From: [Mau, Russell E \(DOH\)](#)
To: [Zach Torrance-Smith](#)
Cc: [Melissa Schumaier](#)
Subject: Re: SP-26-00005 Ridgway - Notice of Application
Date: Monday, June 15, 2026 4:03:06 PM

The Department of Health (DOH) Office of Drinking Water (ODW) has reviewed the application generating the following official comments:

CDS is requesting comments on the following short plat application: SP-26-00005
Ridgway.

# RIDGWAY SHORT PLAT PART OF SECTION 29, T. 18 N., R. 19 E., W.M. KITTITAS COUNTY, WASHINGTON

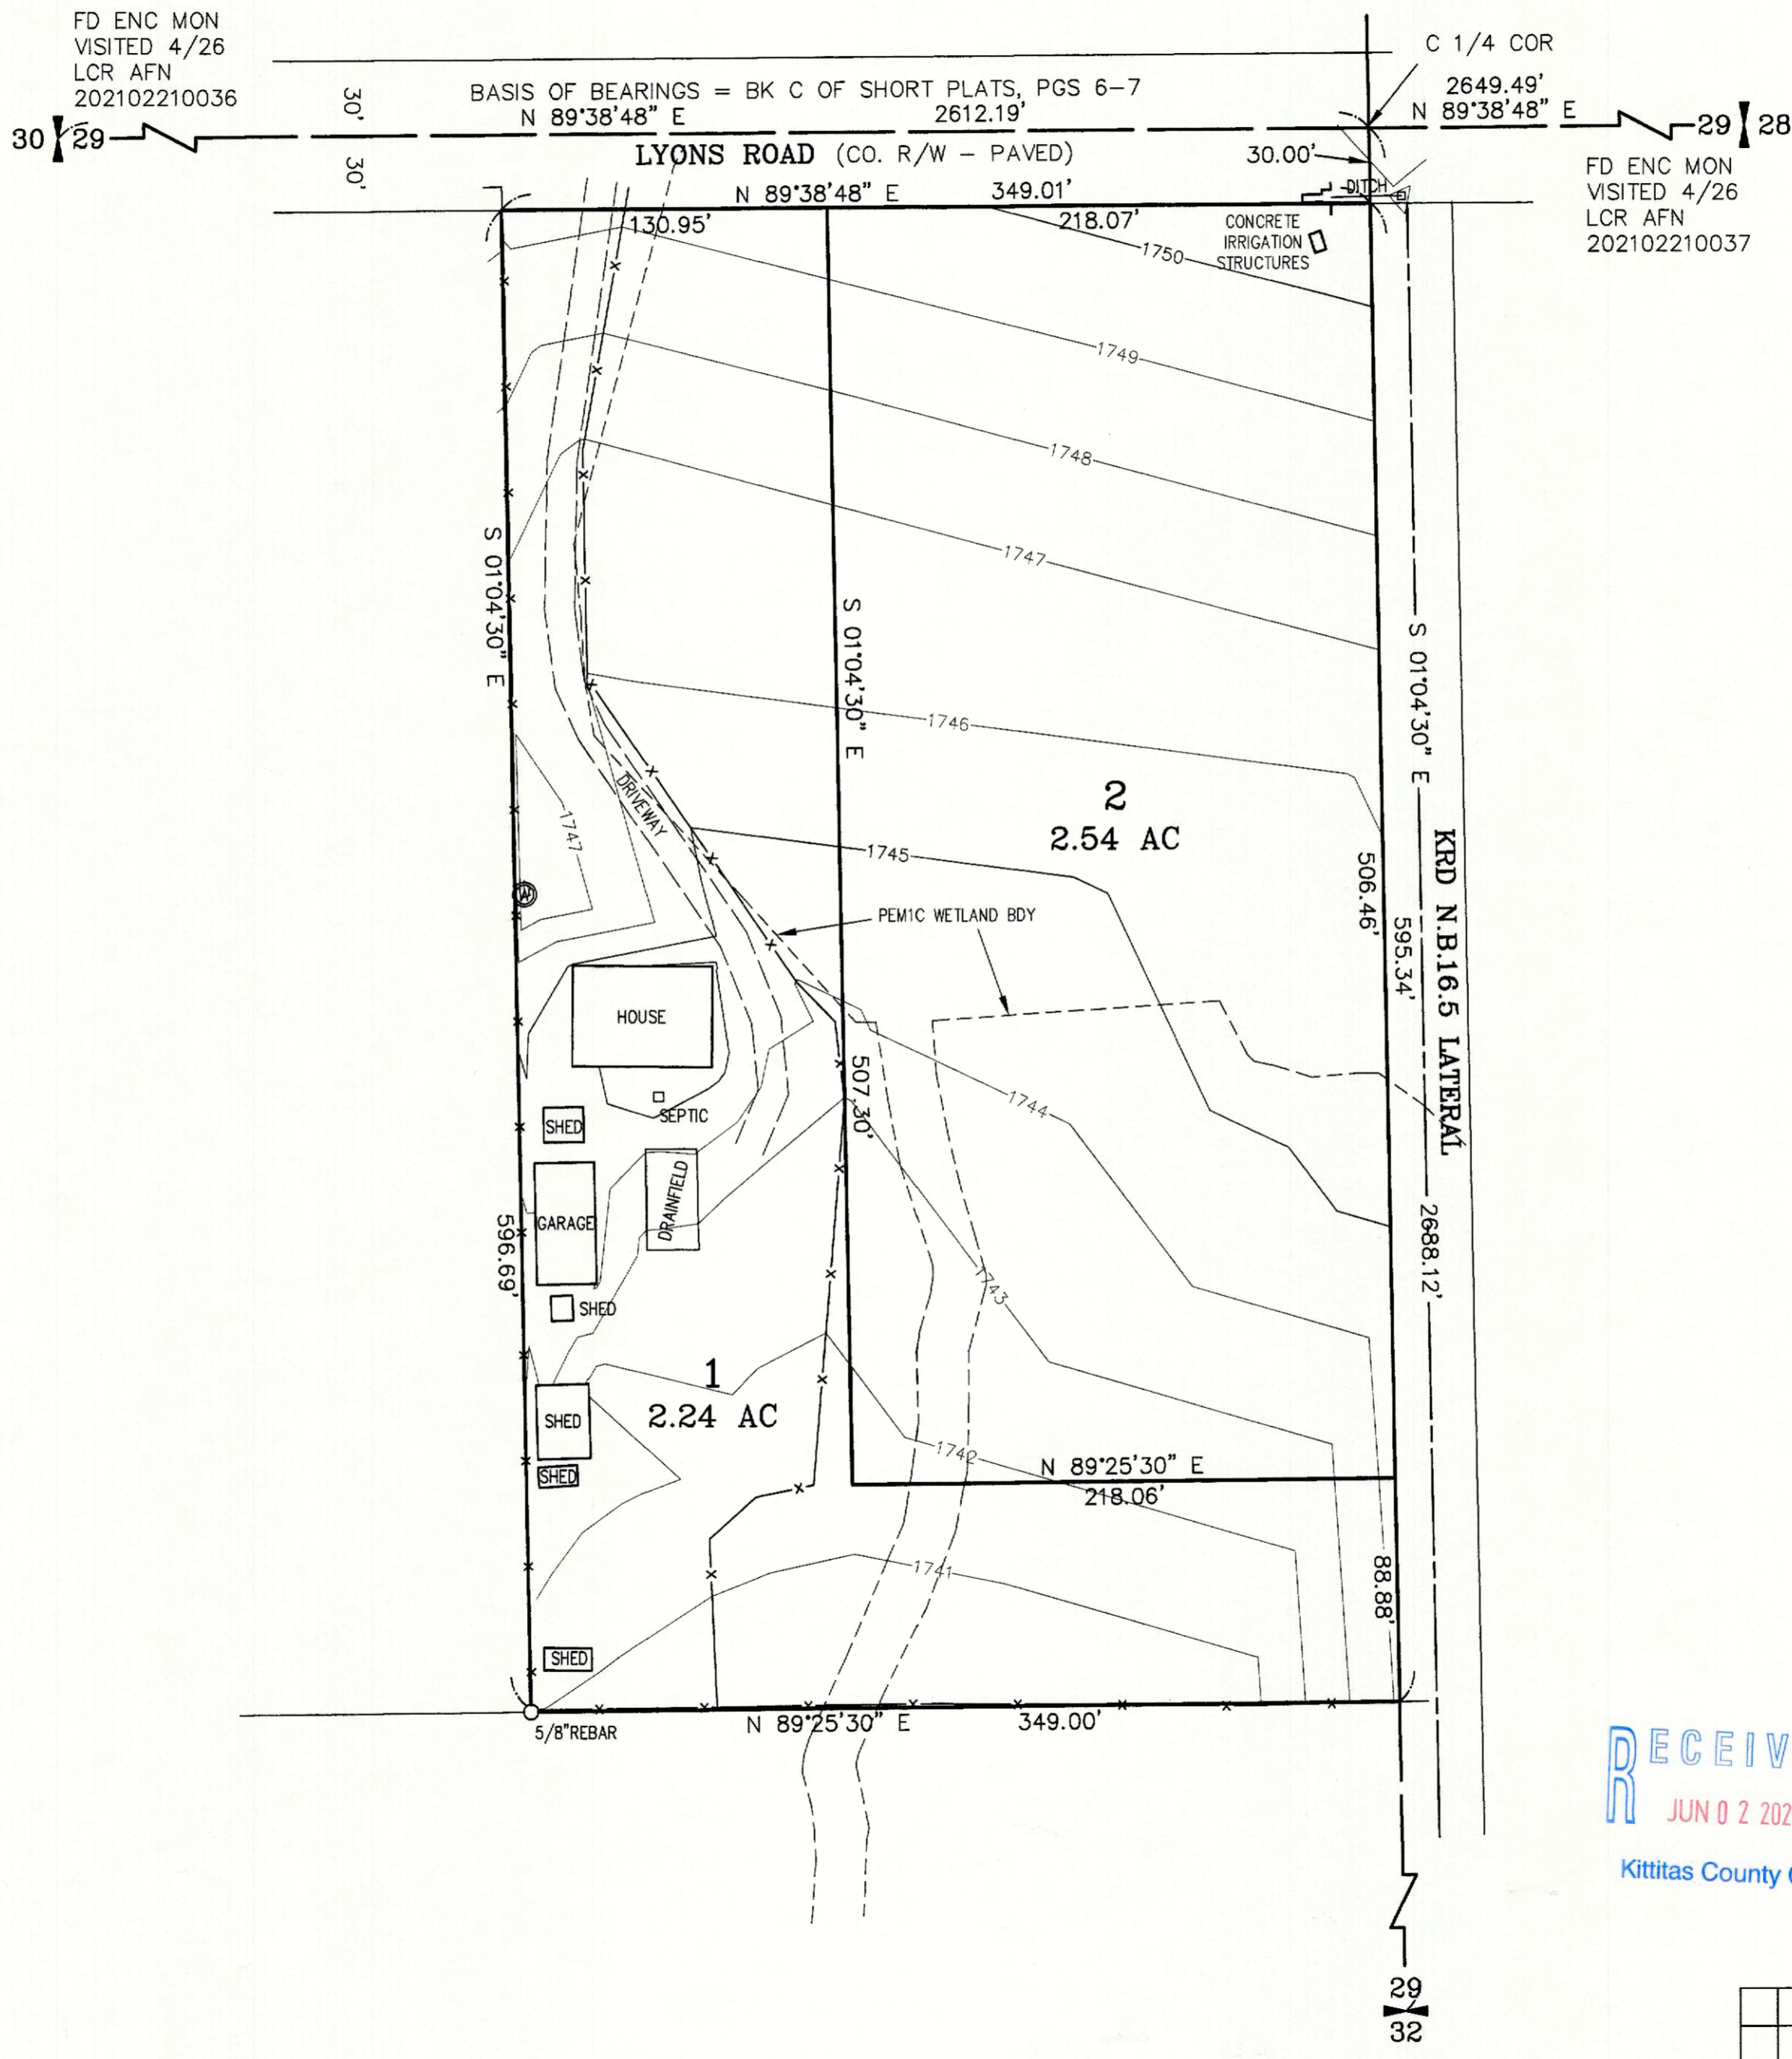
1. A well shared by two residential connections does not meet the definition of a public water system.
2. In the future, if either or both parcels seek an "ADU" connected to the same well, then 3 or more residential connections connected to the same well meets the definition of a public water system needing review.
3. Most likely, the public water system would be a Group B under the exclusive jurisdiction of Kittitas County Health.
